DARLINGTON TERRACES CONSULTATION MEETING WITH THE CITY OF SYDNEY

10am to 11am Friday, 13 May 2016
City of Sydney Offices

01 - DARLINGTON TERRACES - PROPOSED ENVELOPE PLAN

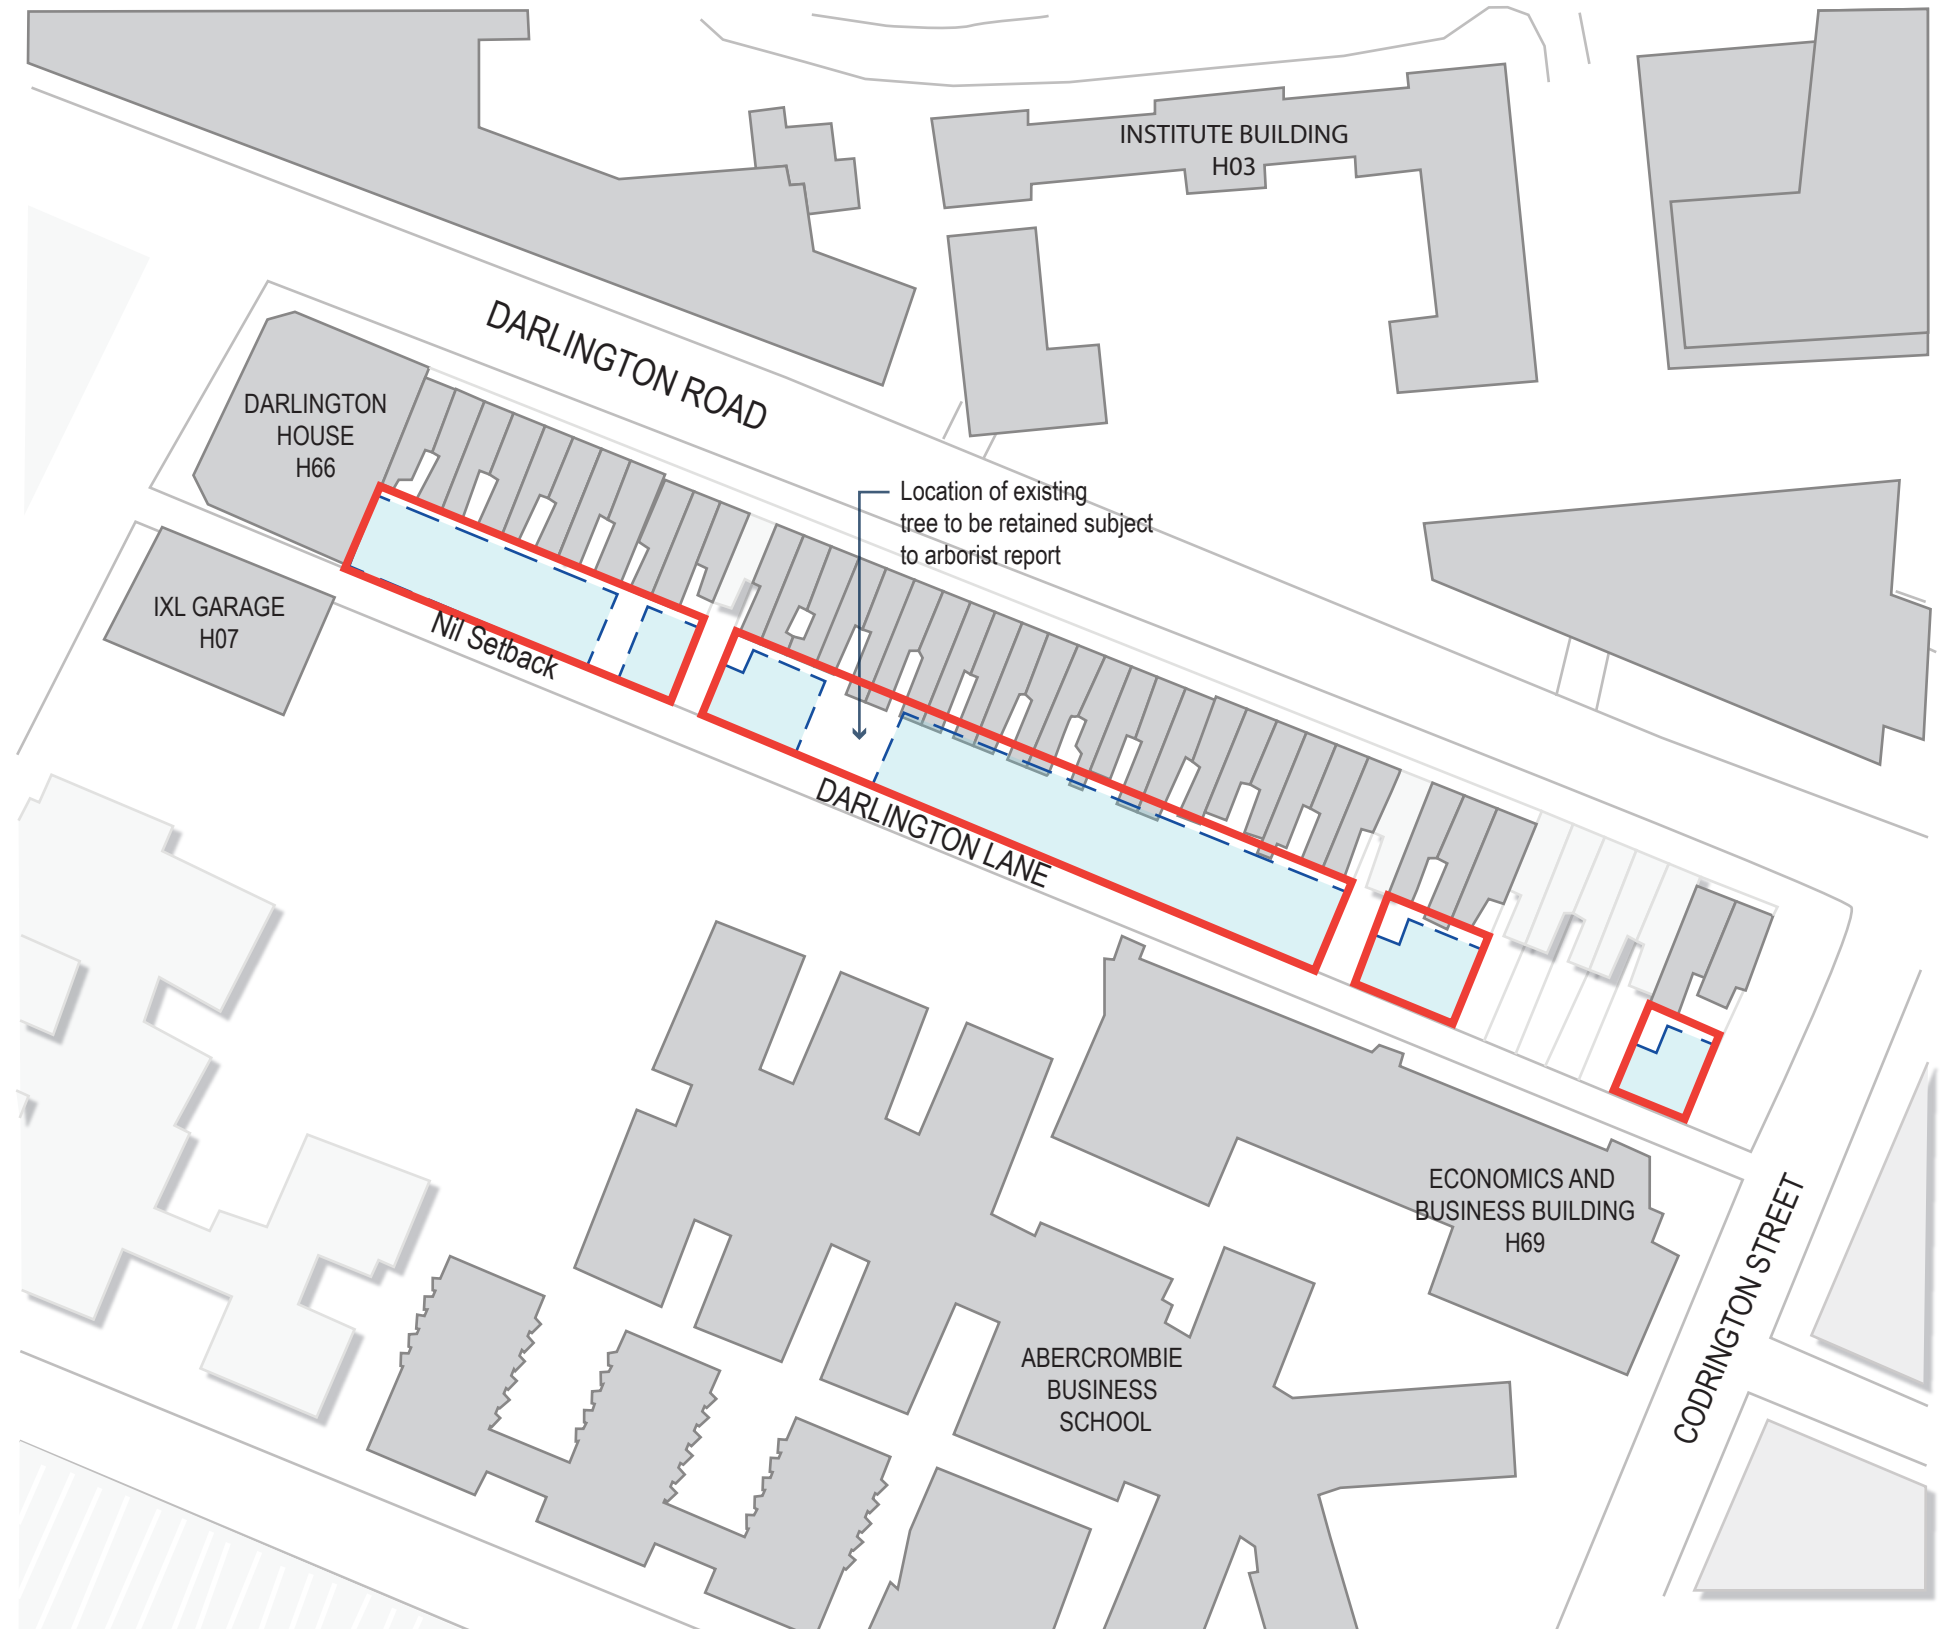
- 7 **CIP Building Envelope:**
CoS noted two minor areas of building protrusion above CIP envelope.
AJ+C confirmed intention to achieve 100% full CIP envelope compliance.
However current scheme has minor protrusions of 60-100mm.
CoS noted that this is not a great concern as the majority of design is well below CIP height limit, overall subservience to the host terrace ridgelines is achieved, and the building additions will not be visible from Darlington Road.
CoS also noted that the main area of protrusion was adjacent the retained tree so that the exposure of the existing rear Terrace facades would be preserved when viewed from side Abercrombie Business forecourt.
